Norfolk Boreas Offshore Wind Farm Schedule of Changes to the draft Development Consent Order (Version 5) (Clean)

Applicant: Norfolk Boreas Limited
Document Reference: ExA.SCh.D7.V5
Deadline 7

Date: March 2020
Revision: Version 5
Author: Womble Bond Dickinson

Schedule of Changes to the draft DCO

**APPENDIX 2: SLIDES SHOWING ONSHORE PROJECT SUBSTATION
INFRASTRUCTURE (AGENDA ITEM 4 (b) I)**

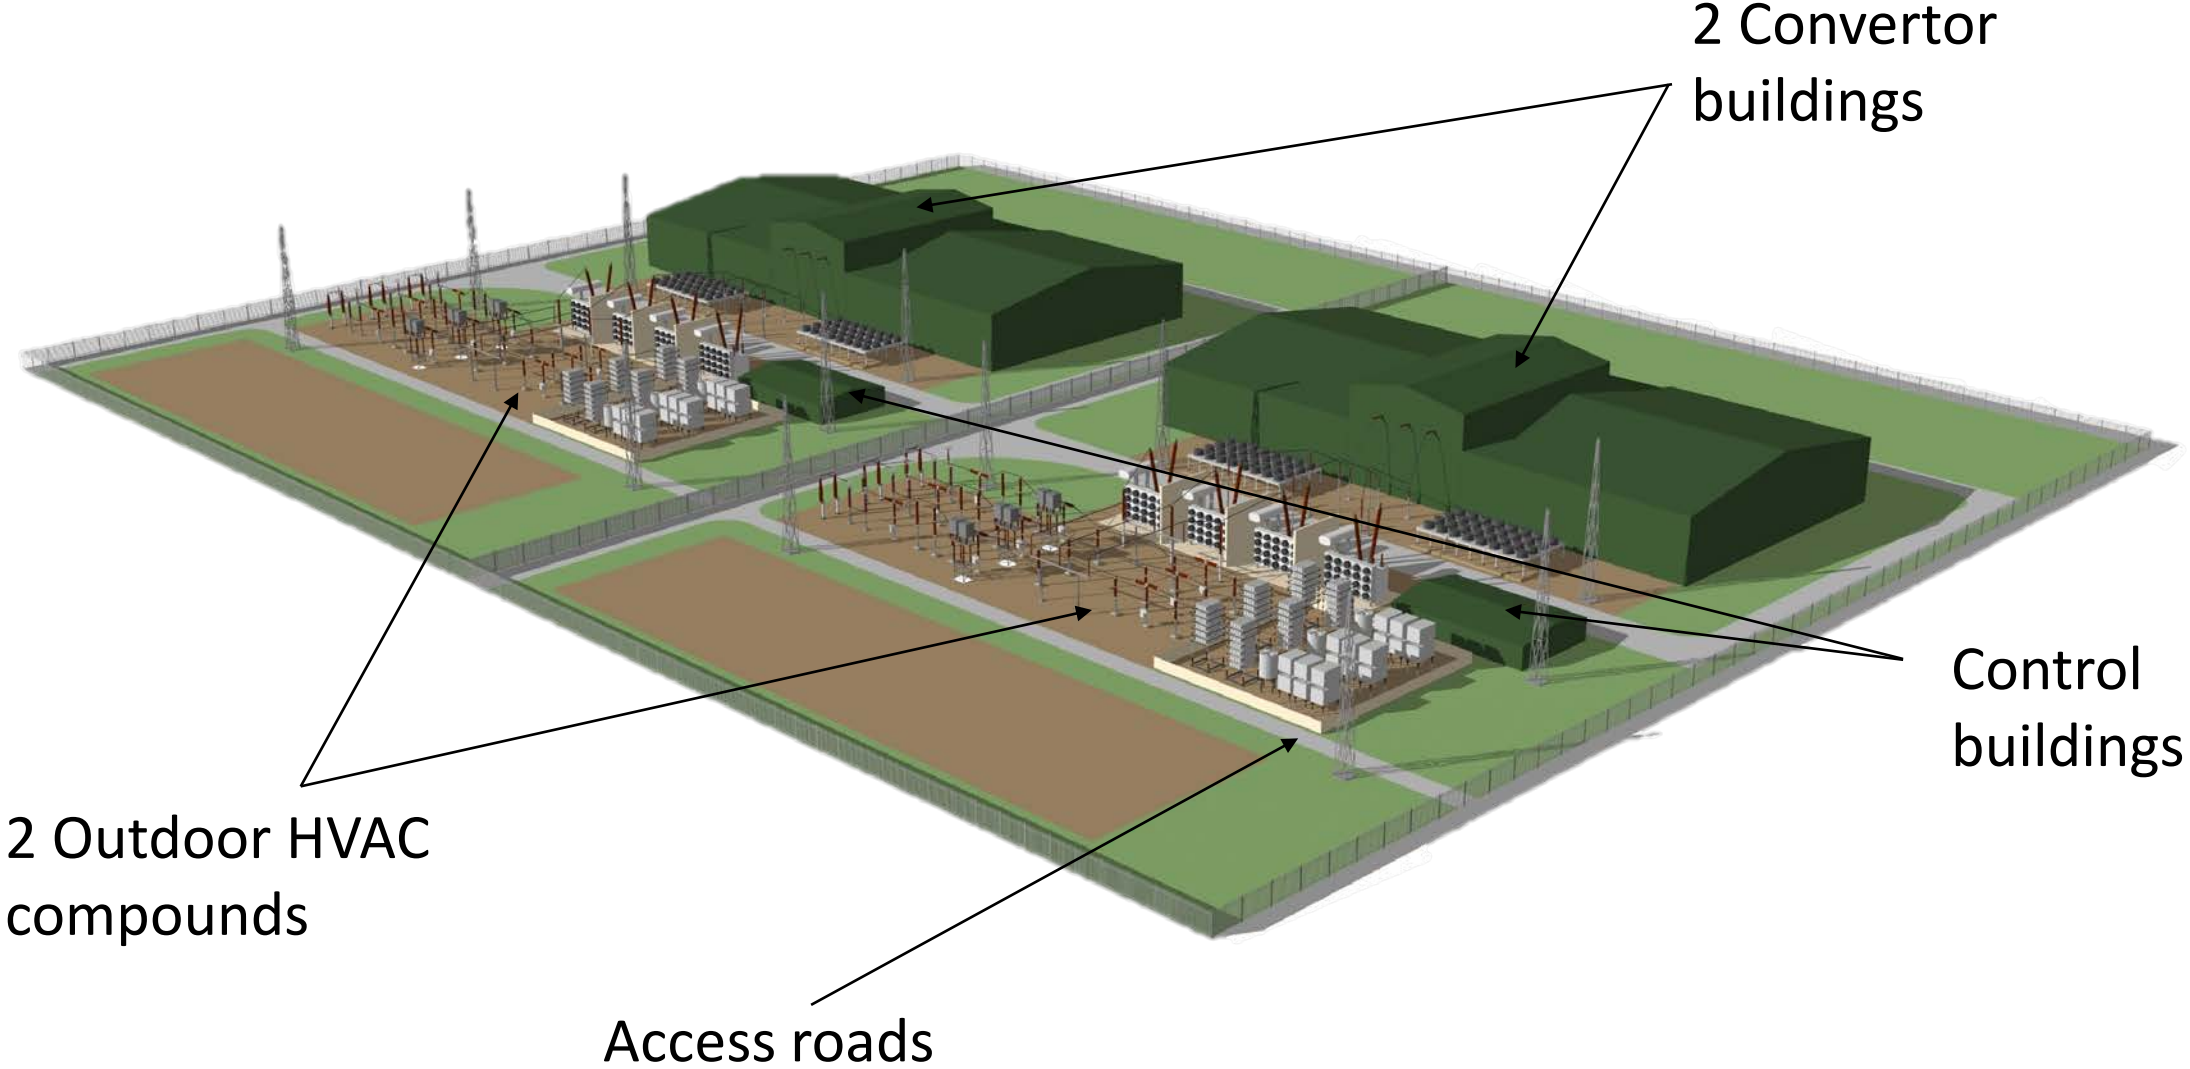
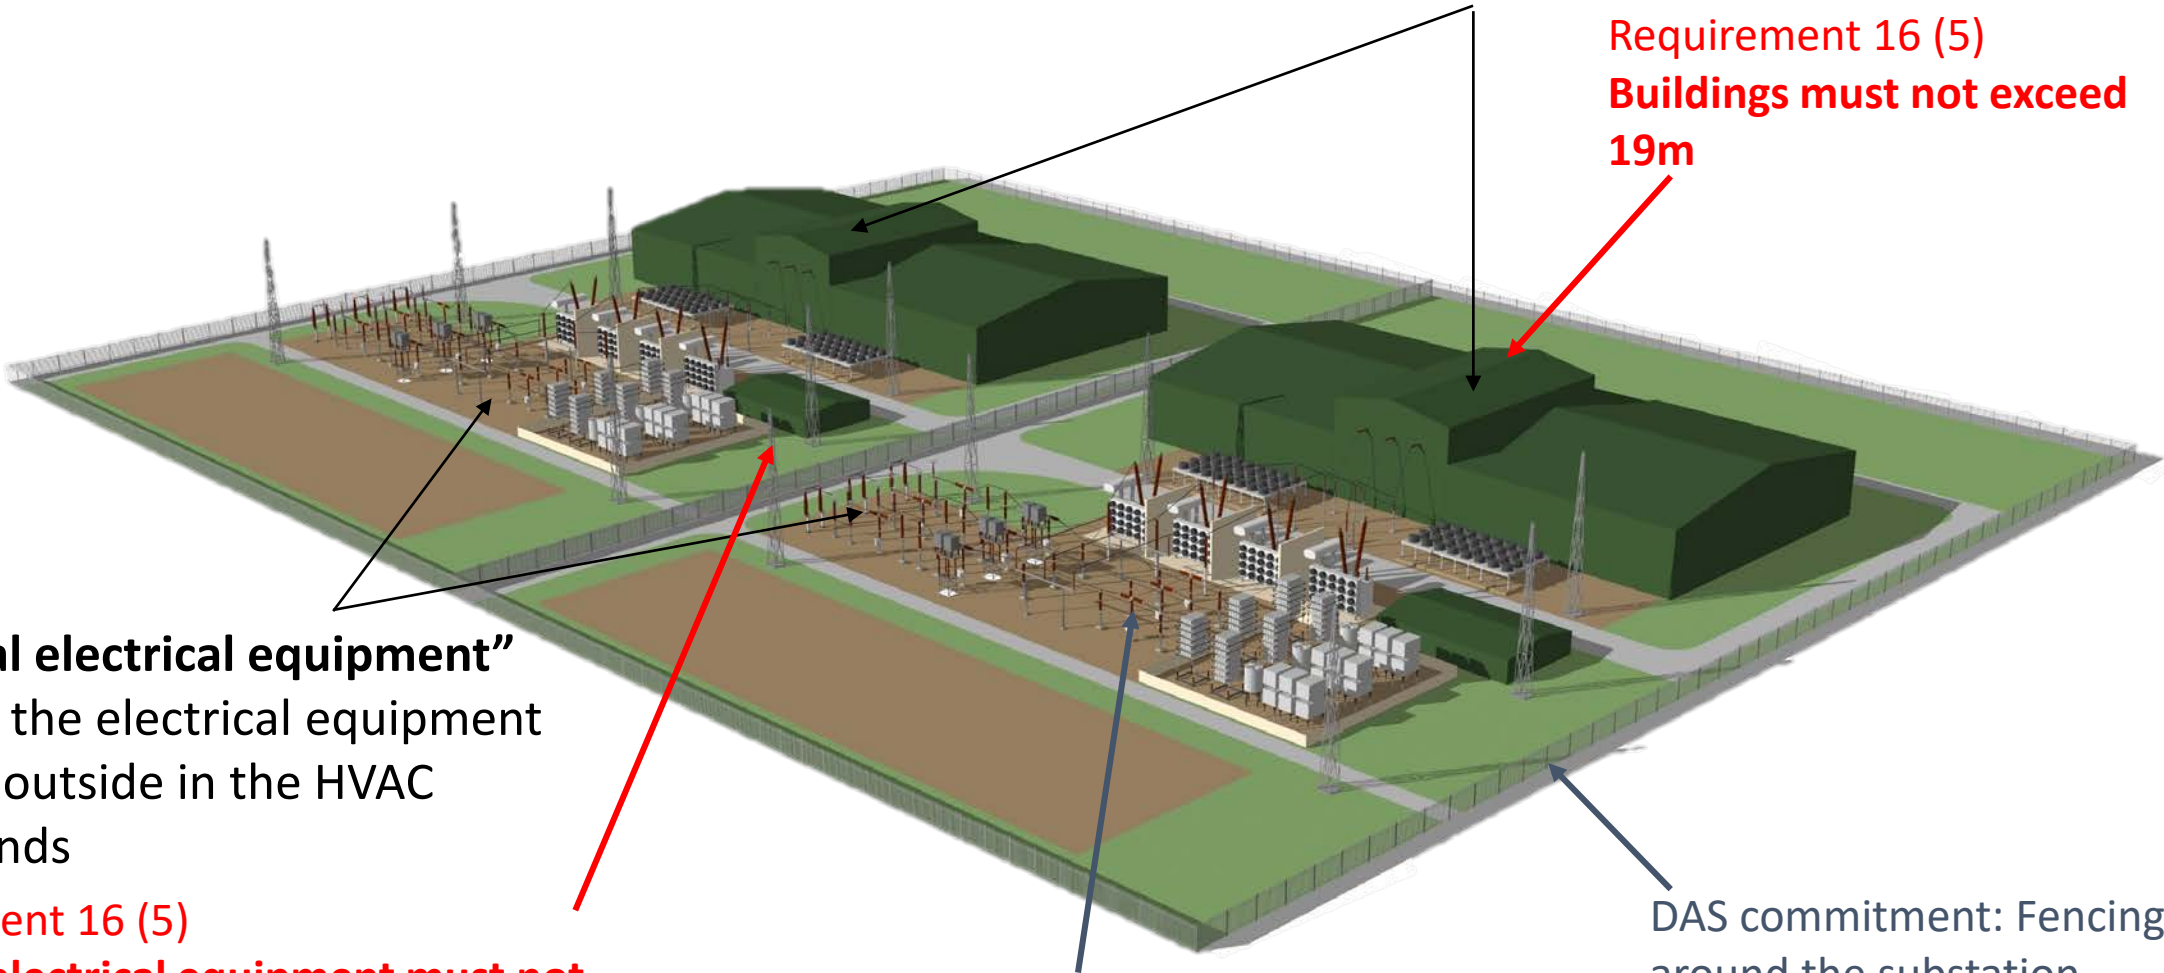
39.	Article 2, Interpretation	ExA	At the hearing into onshore matters held on 21 January 2020, the ExA asked for clarity on the buildings connected to the onshore project substation. The Applicant has therefore inserted a new definition for converter building at Article 2 and referred to converter building in Requirement 16.	<i>"converter building means the building housing the principal electrical equipment comprised in Work No.8A"</i>	4

49.	Requirement 16	ExA	At the hearing into onshore matters held on 21 January 2020, the ExA asked for clarity on the buildings housing the principal electrical equipment. The Applicant has therefore inserted a new definition for converter building at Article 2 and referred to converter building(s) in Requirement 16.	16.—(1) <i>The total number of converter buildings housing the principal electrical equipment for the onshore project substation comprised in Work No. 8A must not exceed two.</i> (2) <i>Construction works for the onshore project substation buildings referred to in paragraph (1) above must not commence until details of the layout, scale and external appearance of the same have been submitted to and approved by the relevant planning authority.</i> ... (5) <i>Buildings (including the converter buildings) comprised in Work No. 8A must</i>	4

<p>not exceed a height of 19 metres above existing ground level and external electrical equipment comprised in Work No. 8A must not exceed a height of 25 metres above existing ground level.</p> <p>(6) The total footprint of each <i>converter building housing the principal electrical equipment for the onshore project substation comprised in Work No. 8A</i> must not exceed 110 metres by 70 metres.</p>
